CITY OF ALBUQUERQUE

**Re: Wilderness Cañon at High Desert
Report Dated 8/9/15
Grading & Drainage Plan
Engineer Stamp Date 8/12/15(F23D012)**

Based upon the information provided in your submittal received 9/10/15, the above referenced plan is approved for Preliminary Plat and Site Plan for Building Permit action by the DRB.

GRADING PLAN

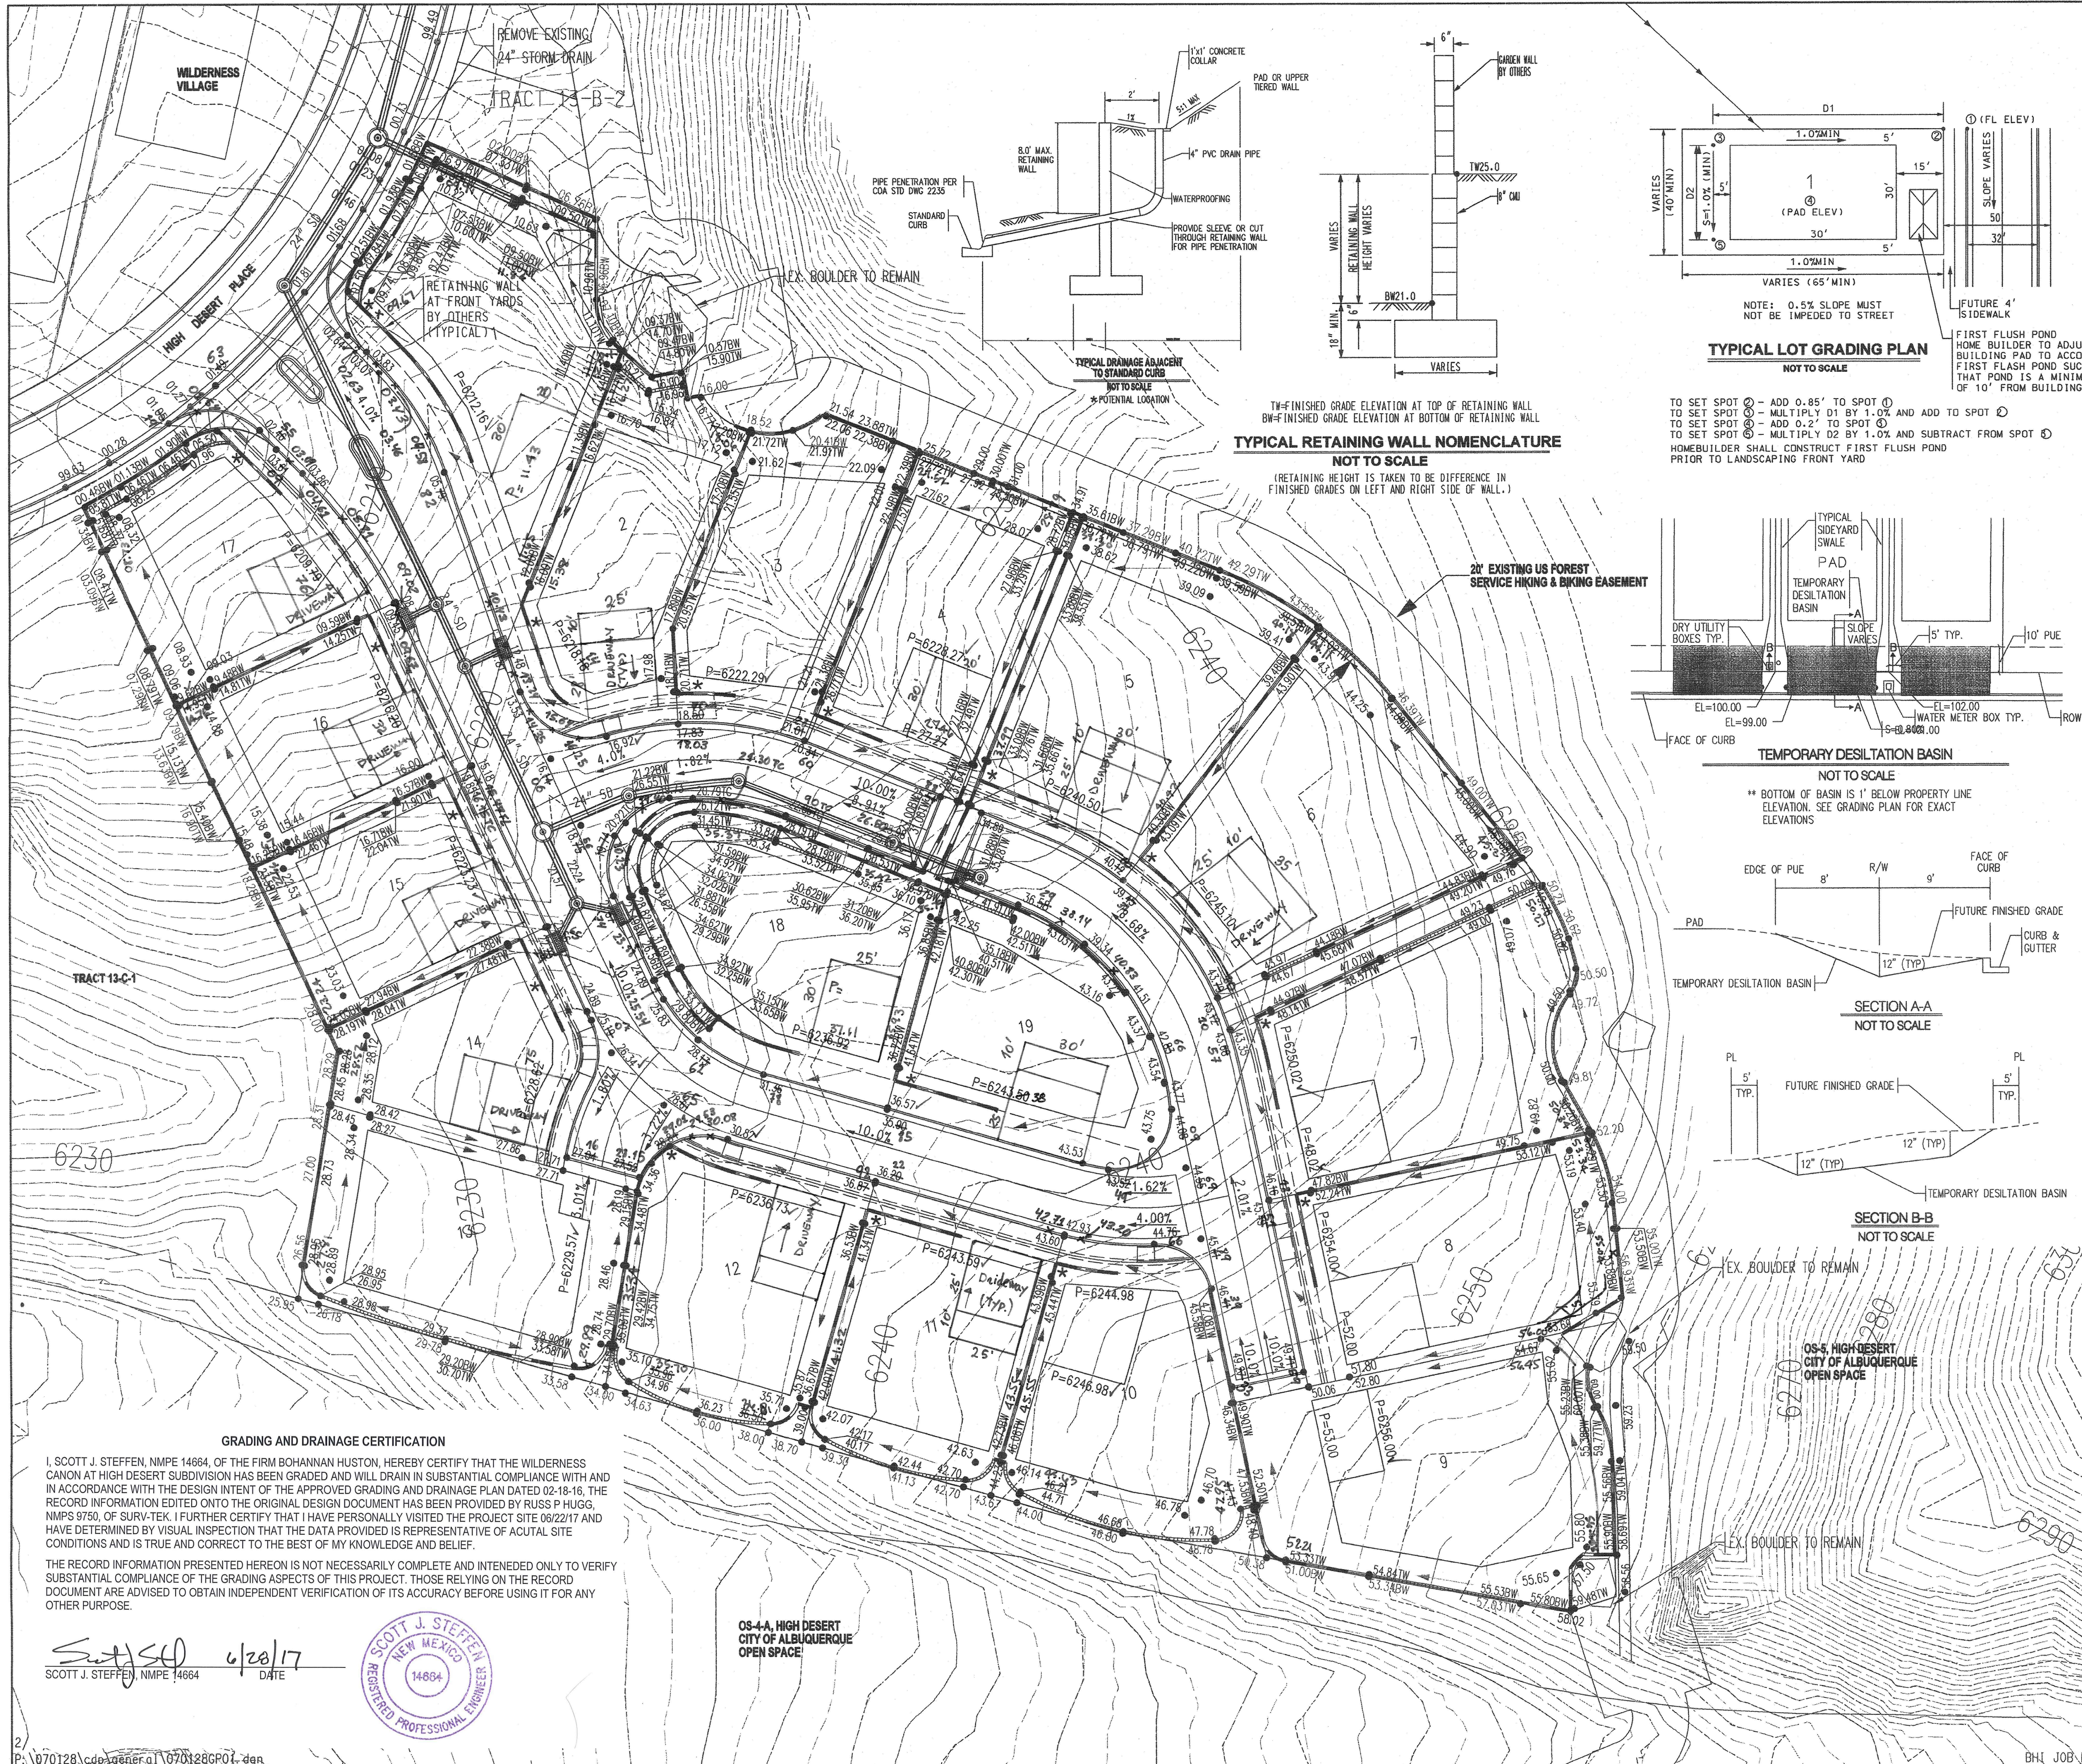
1. Provide actual pad size on each lot showing the location of the "First Flush" pond.
2. Provide an asterisk for lot 18 showing the location of the drainage for this lot.
